**Our ref:** OR-0002993/01  
**Your ref:** EN010153  
**Date:** 29 April 2026

**ENVIRONMENT AGENCY DEADLINE 7 RESPONSE.**

**FRODSHAM SOLAR PROJECT, FRODSHAM MARSHES**

Indicative Watercourse
Crossing Points

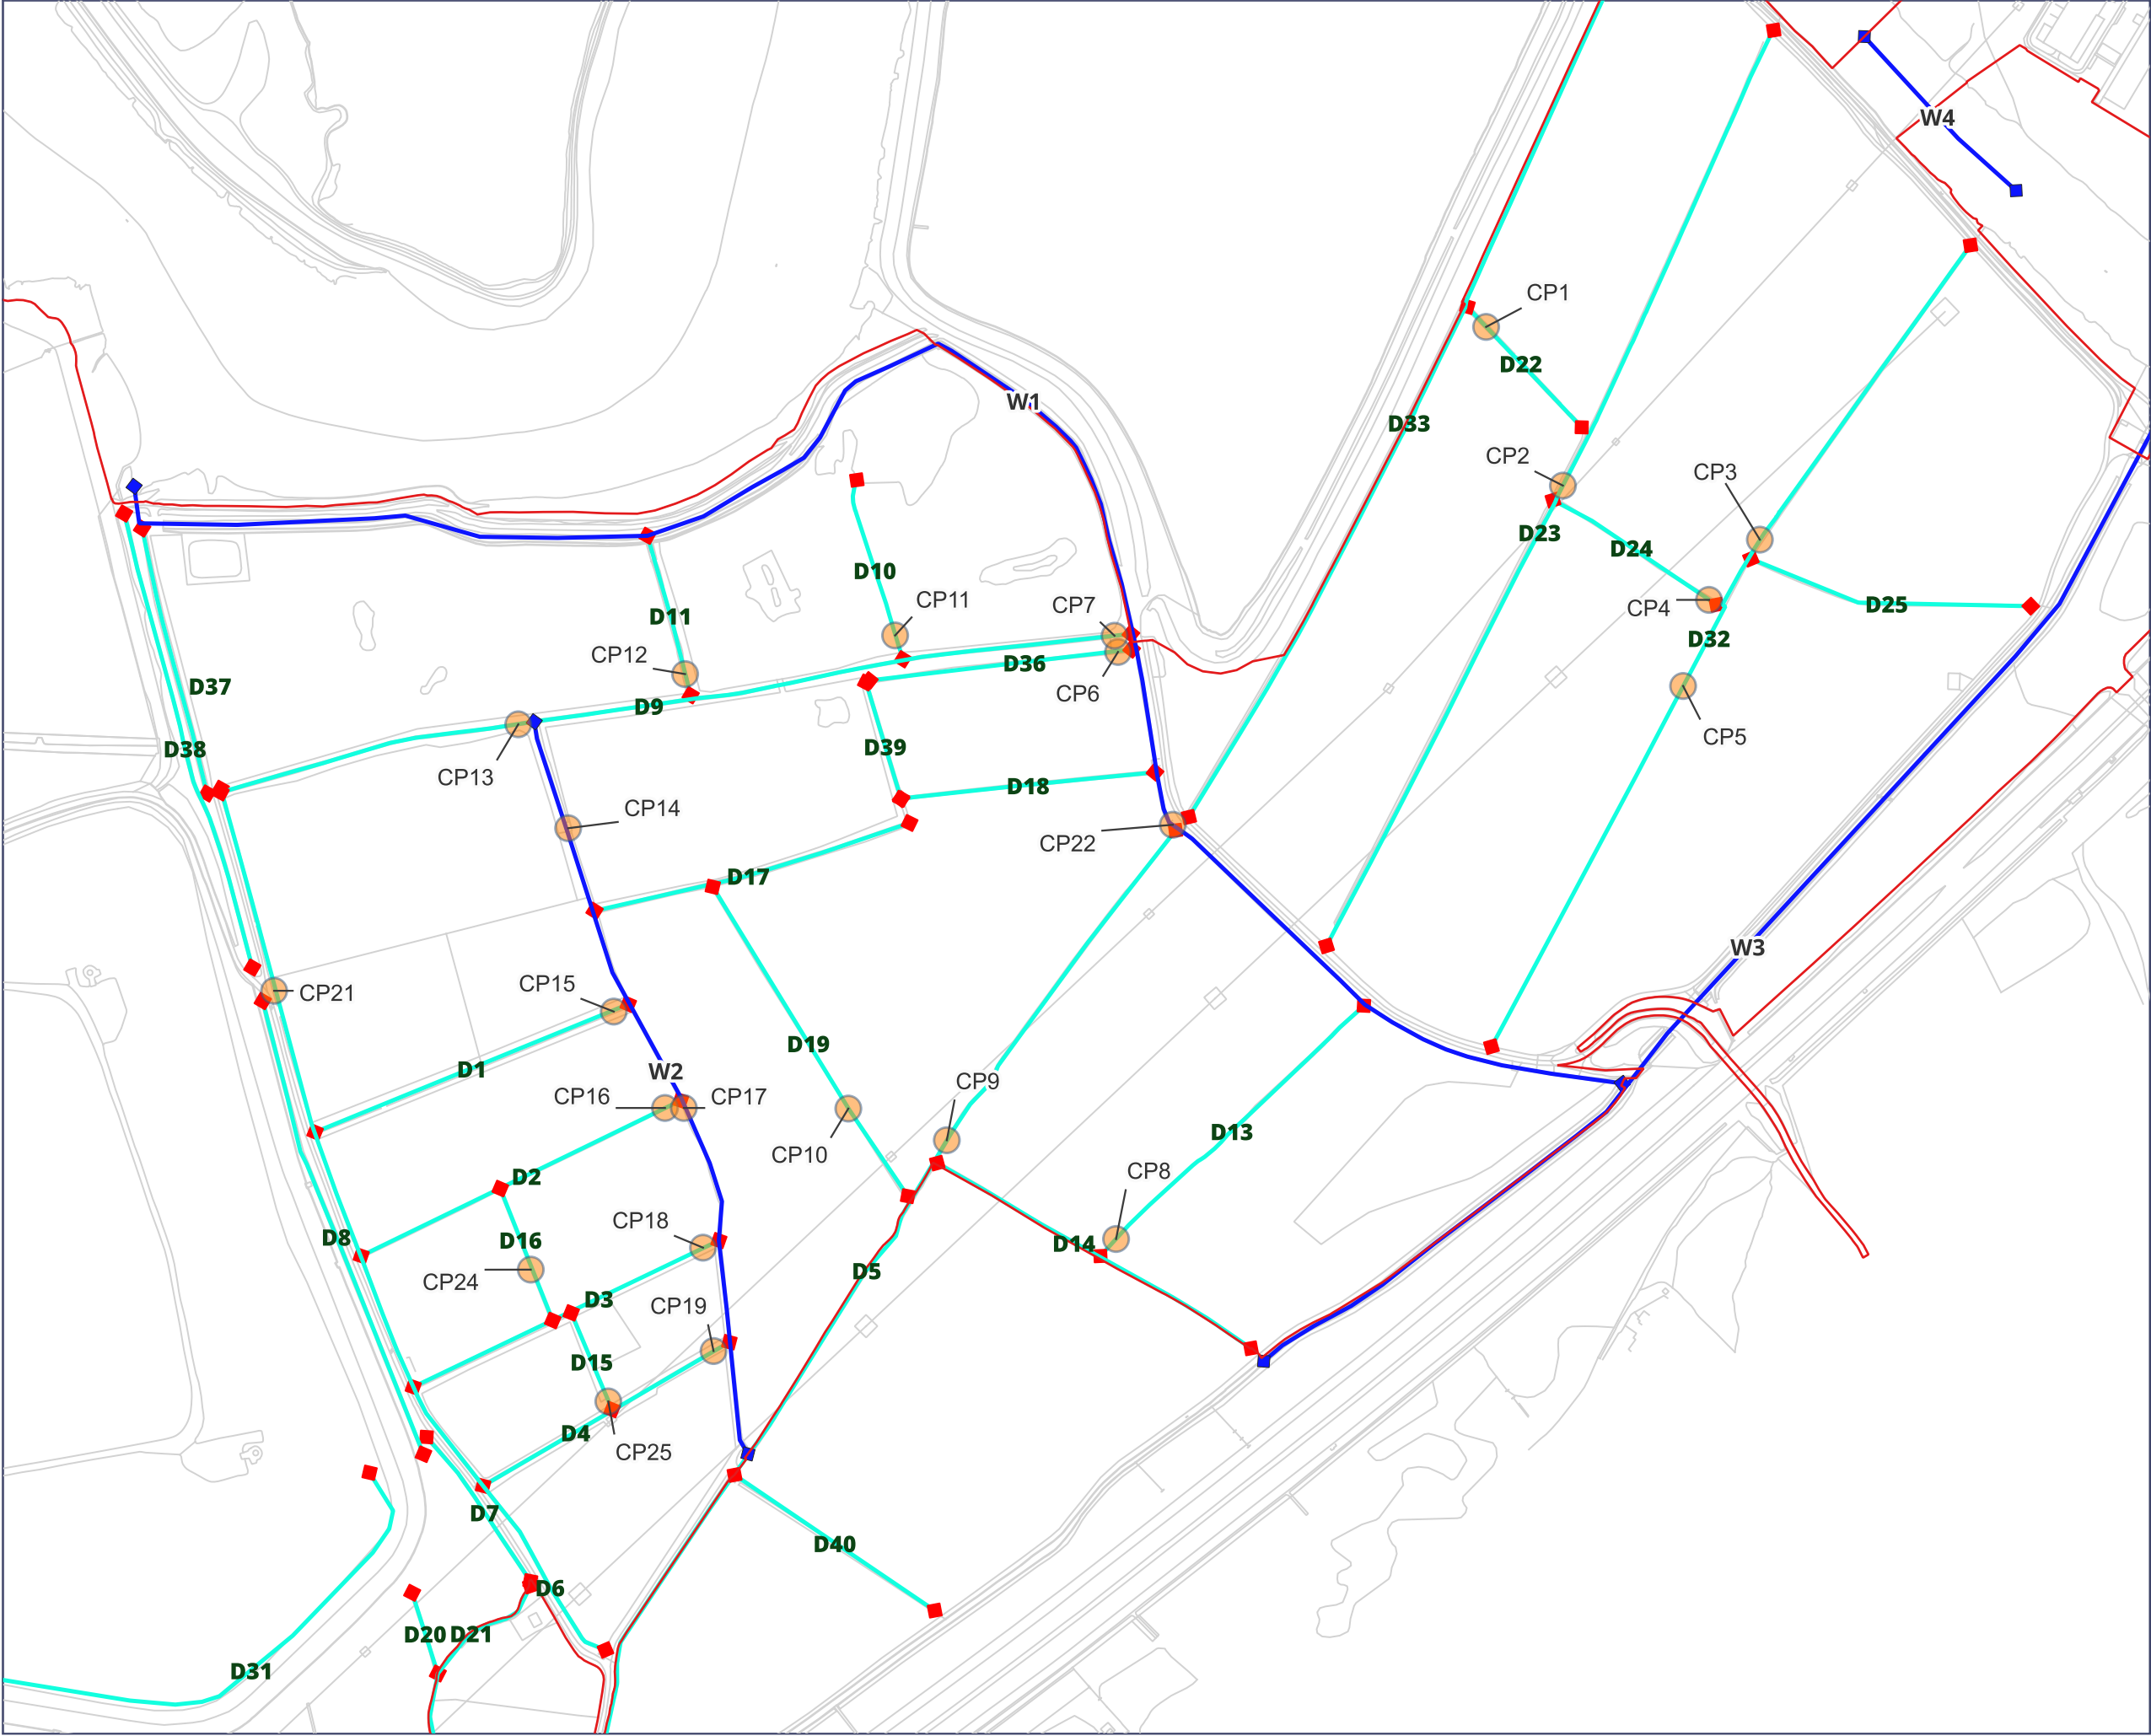
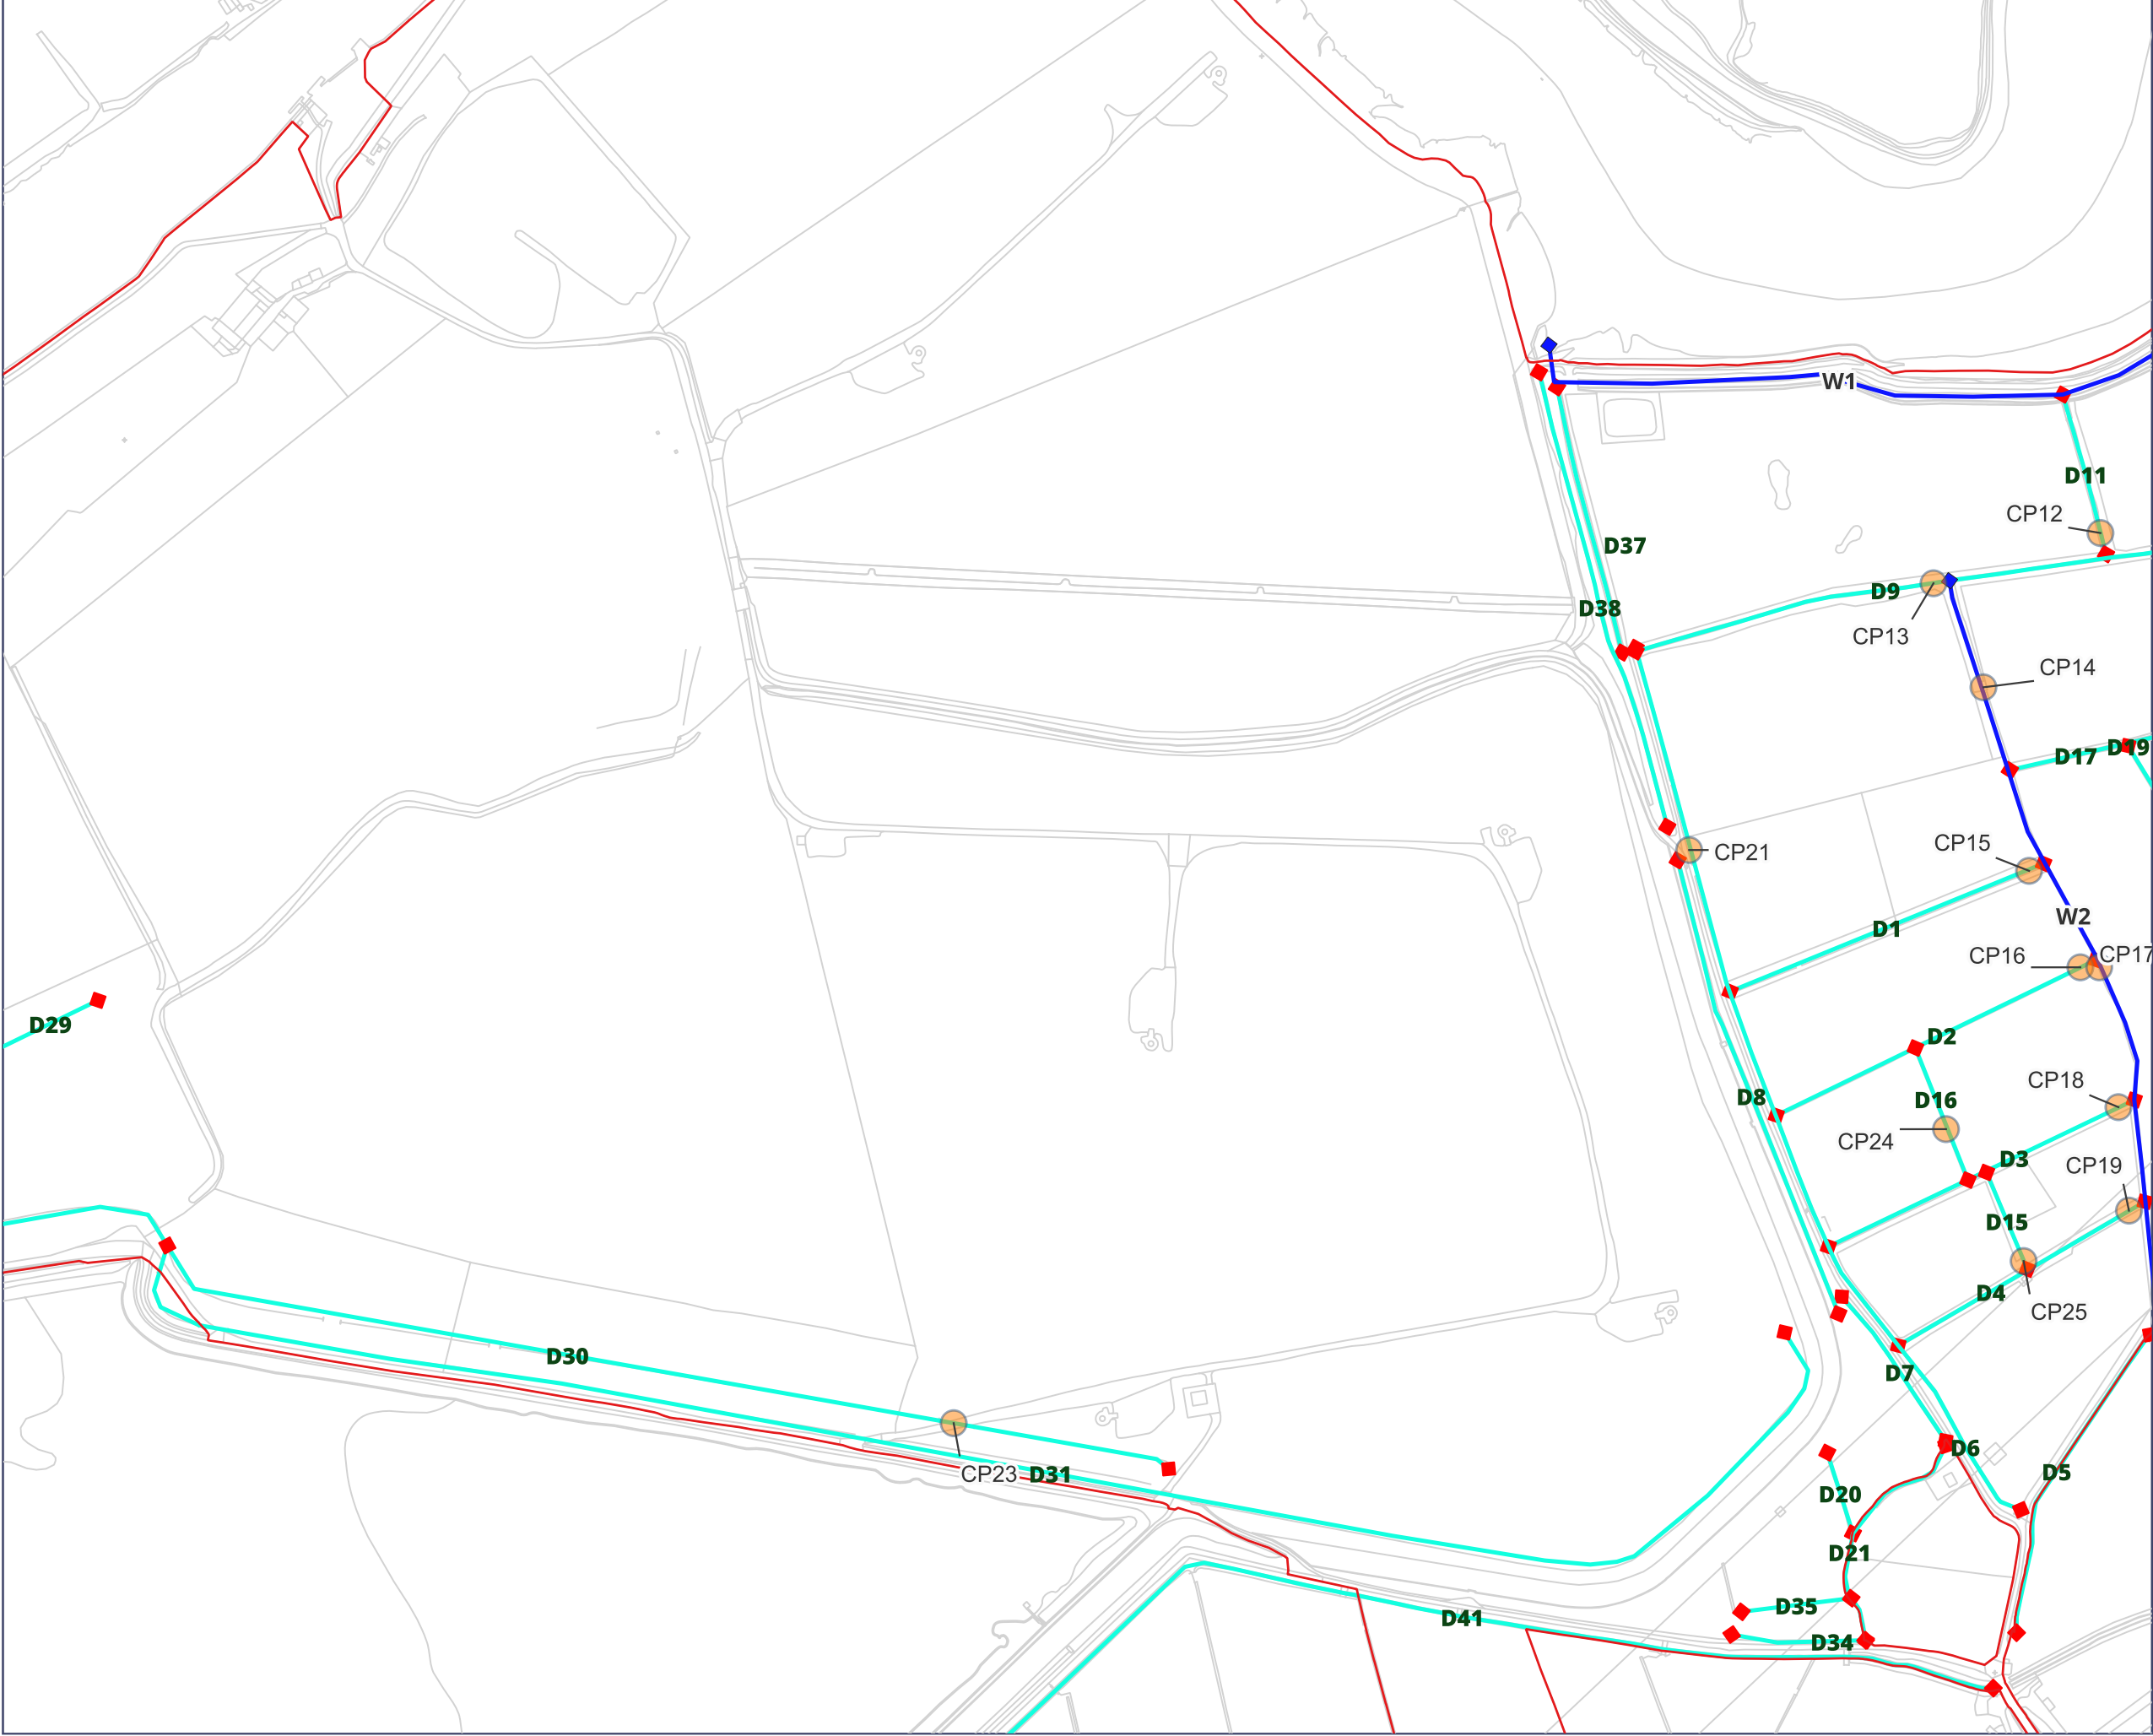
The Applicant has provided an adequate crossing design for bridge CP22 under the 8.52 CP22 Technical Note - P01 [[REP6-042](#)] that provides appropriate 300mm freeboard above the design flood event (1% AEP plus 67% CC - higher central allowance). We are content with the crossing designs for CP14 and CP17.
